Application No: LU/55/22/L
Site Address: The Flintstone Centre East Street Littlehampton BN17 6AW
Description of works: Listed building consent for the installation of 3000mm high welded mesh fencing and associated single leaf gate along a section of the northern boundary line and along the rear elevation, Ornamental fencing and associated gates to be installed, located adjacent to the existing southern side entrance to the building, as well as the installation of 3000mm high welded mesh fence encapsulating the existing boiler room to the rear of the building, demolition of existing side secondary entrance including existing ramped access and associated fittings. Repairs to the section of wall affected by the removal of the entrance.

Thank you for your internet representation made on 8th March 2022 which has been recorded as an objection with the comments as follows:

OWPC44997

Title:
THE FLINTSTONE CENTRE
FENCING LAYOUT AS PROPOSED

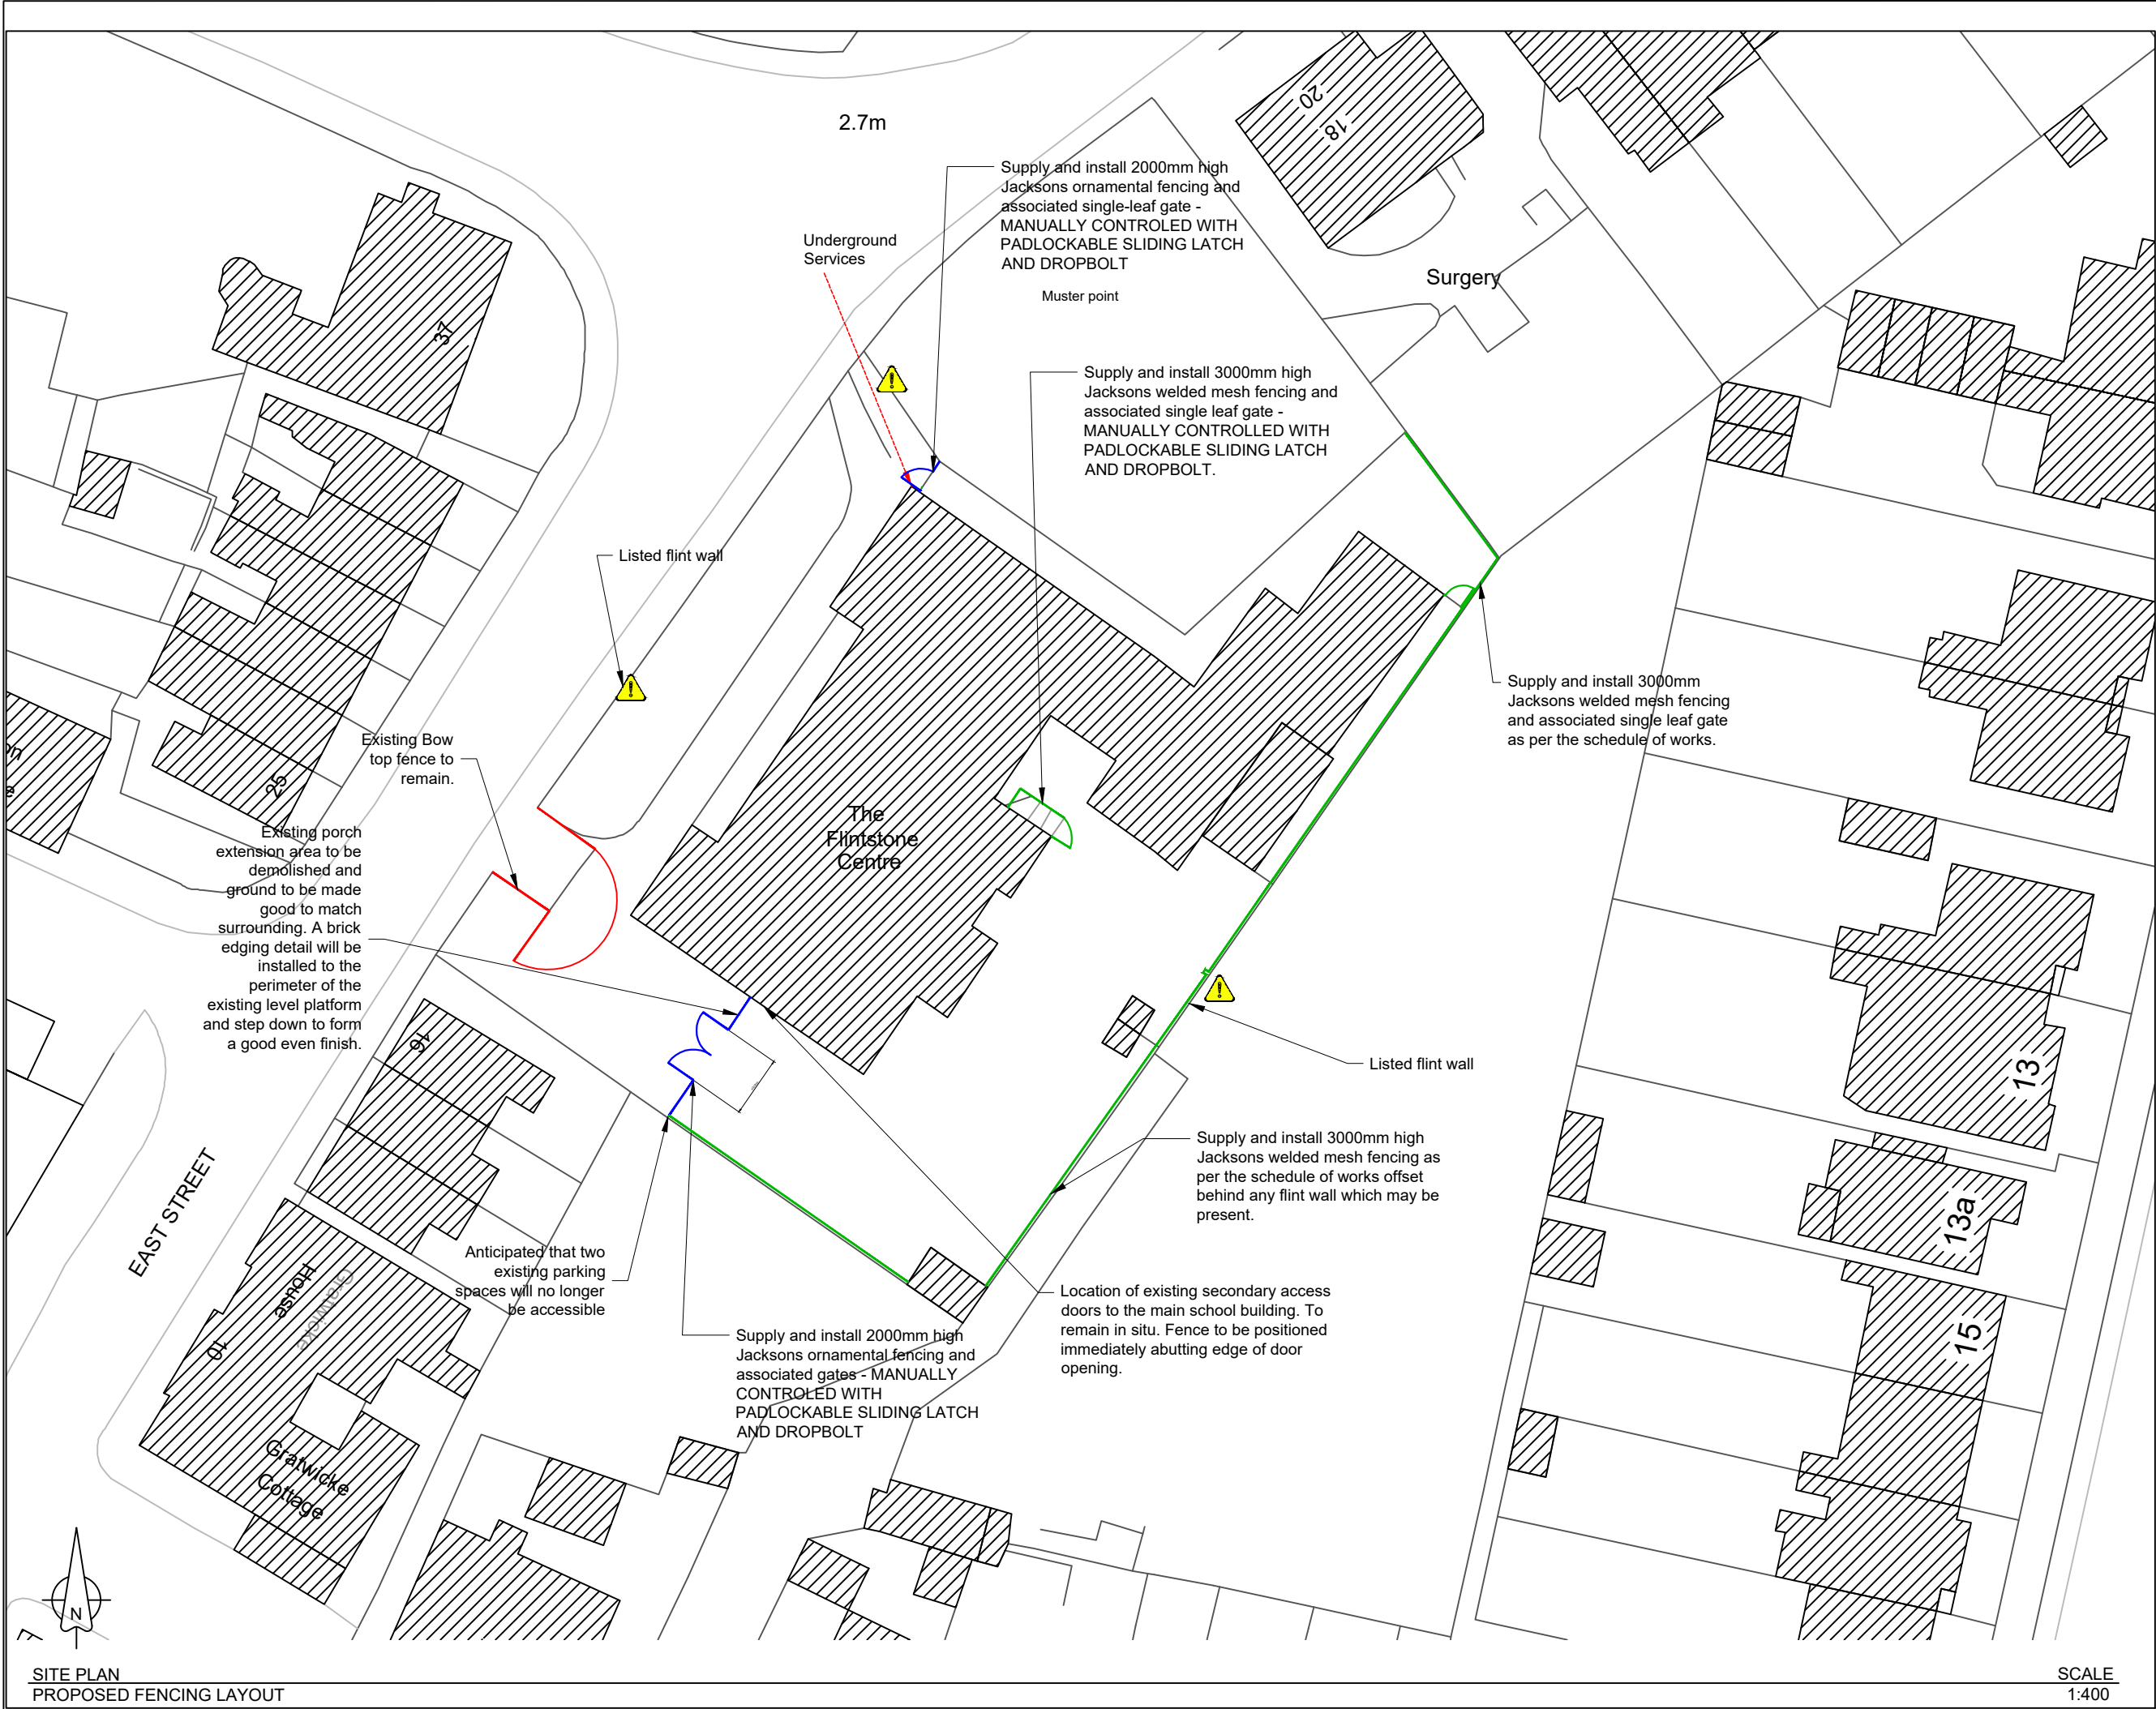
The planned Euroguard Weld mesh fencing is totally inappropriate for the site at the rear of the Flintstone Centre. We at The Old Dairy Farm development will be looking straight at the prison like fence only approx 3 metres from our property, which is unacceptable. The fence should be as originally discussed (planned?) & an ornamental heritage style fence as befitting the conservation area be installed. We support & agree all more detailed comments supplied by our Dairy Farm neighbours.
